Campaign for Better Transport

WRITTEN REPRESENTATION

HIGHWAYS ENGLAND'S RESPONSE

Figure 1: NO₂ Projections Informing IAN 170/12 v3

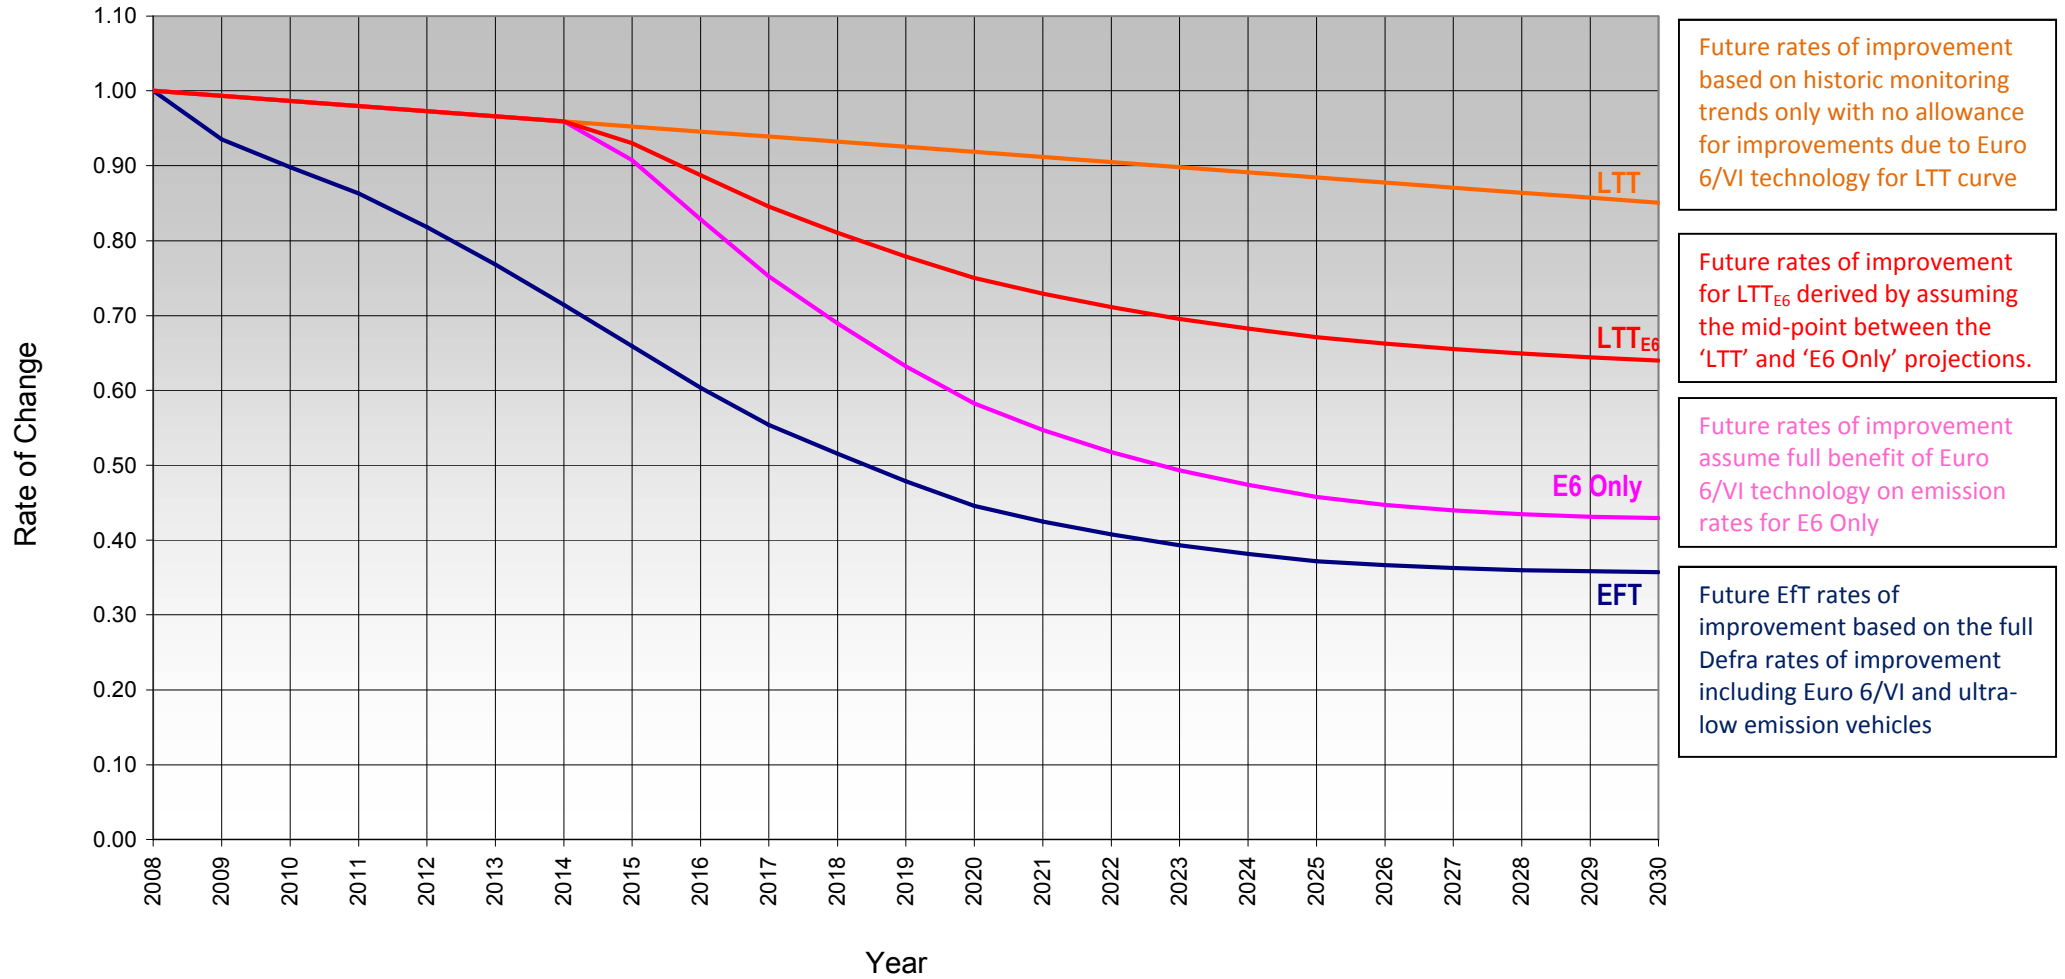
1.2.2 What Highways England has not said in these statements is that IAN 170/12 v3 allows for a choice of long term trend to be used and that Highways England has chosen the more optimistic of these trends. It is worth noting that IAN 170/21 v3 states:

The annual projection factors are provided by the HA between 2008 and 2030. The long term trend is assumed to be linear as there is no observed long term impact of emissions from Euro VI vehicles on air quality monitoring trends available at this time. As such the precautionary principal is applied to future projections. Beyond 2017 the projections are expected to be conservative, but as more information becomes available the long term trend projections will be reviewed and this IAN updated accordingly.⁶

1.2.3 It is clear from this statement that there is a level of uncertainty about future projections, particularly beyond 2017. While it states that these are addressed in a conservative way, this was written before the recent exposure of emissions cheating by Volkswagen (VW) and the revelation that many diesels are emitting more pollution than they are supposed to.

1.2.4 Therefore, Highways England has still not explained why the more conservative Long Term Trend (LTT) line from IAN 170/12 v3 was not used. It has attempted to claim that the LTT line is an almost static trend, which makes it sound as though it does not allow for any improvement in air quality when it does.

1.2.5 The line actually falls in a linear way allowing for a steady improvement year on year and the gradient of this line is the same as the gradient of LTT_{E6} after 2026. What Highways England has failed to do is justify how the rapid improvement seen in LTT_{E6} after 2014 is

1.2.6 *It is also worth noting that IAN 170/21 v3 is uncertain about future trends beyond 2017, when LTT_{E6} is still showing a fairly rapid improvement in pollution levels. At the risk of repetition, given all we now know, this must raise questions as to how sound these projections are and we would urge the Examination Authority to have the air pollution data rerun using the more conservative LTT line.*

6. Highways England's position is as noted in CBT's representation above: the LTT curve does not include the anticipated benefits of Euro 6/VI technology, which in the opening year of the Scheme is projected to be a significant component of the vehicle fleet with the associated reductions in emissions. Therefore, it would be inappropriate to use an LTT curve in the Scheme assessment which is not capable of reflecting reductions in emissions and associated pollutant concentrations.

7. As such, Highways England considers that the LTT projection is overly pessimistic, and would not represent a realistic worst case scenario as is required by law. As noted in Advice Note Nine: Rochdale Envelope, page 8 *“The EIA should assess the likely worst case in terms of the potential variations within a project but the detailed design of the project and the variations should not vary beyond these limits so that the proposals as built would not have been assessed, thereby rendering the ES inadequate.”*

8. Interim Advice Note 170/12 v3 also includes two less conservative projections (EFT and E6Only) which have not been used because the LTT_{E6} curve has been preferred. The use of any curve to project future air quality within the assessment for the Scheme, which is more conservative than the Defra (EFT) projections, already goes beyond the requirement of the NN NPS paragraph 5.8 which states that:

PLAN
SCALE 1:200

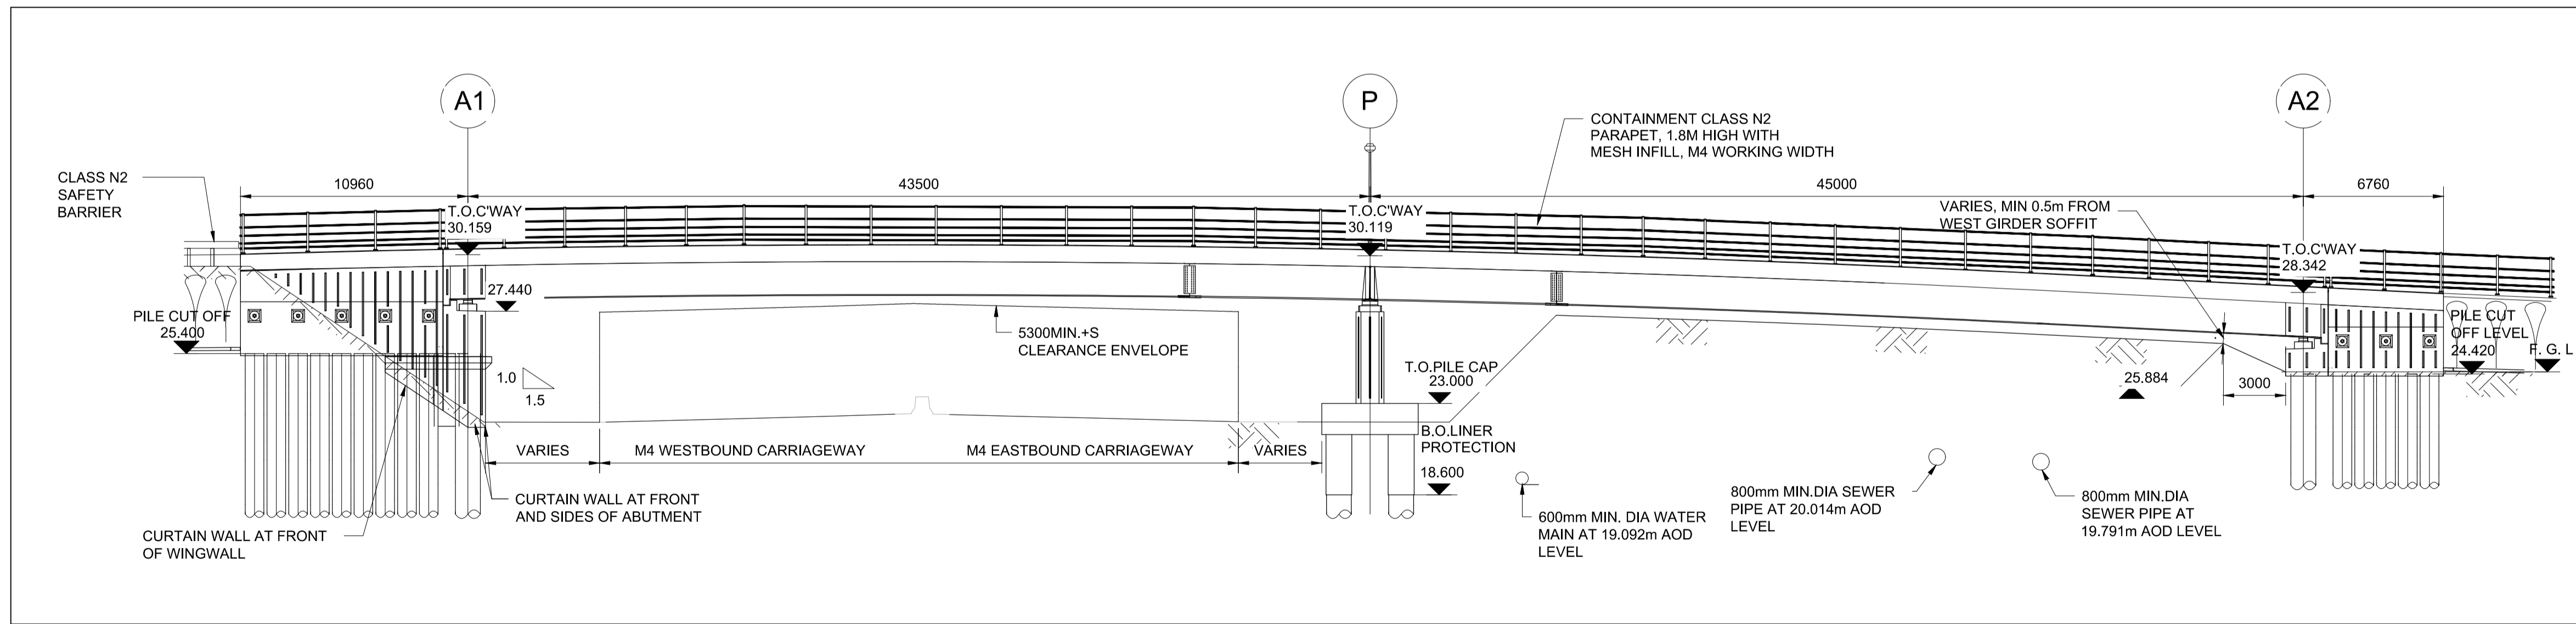
2.2.3.3 *Wood Lane – apart from concern that a 2m shared path is quite narrow, this road has a 20mph speed limit with speed bumps. The raising of the parapets will have no impact on its use and if a segregated facility is being provided for pedestrians and cyclists it should be wide enough so that they can pass each other without fear of snagging on the parapet or wobbling into the traffic.*

30. Highways England considers that this point is addressed in its response to paragraph 2.2.3.1 above.
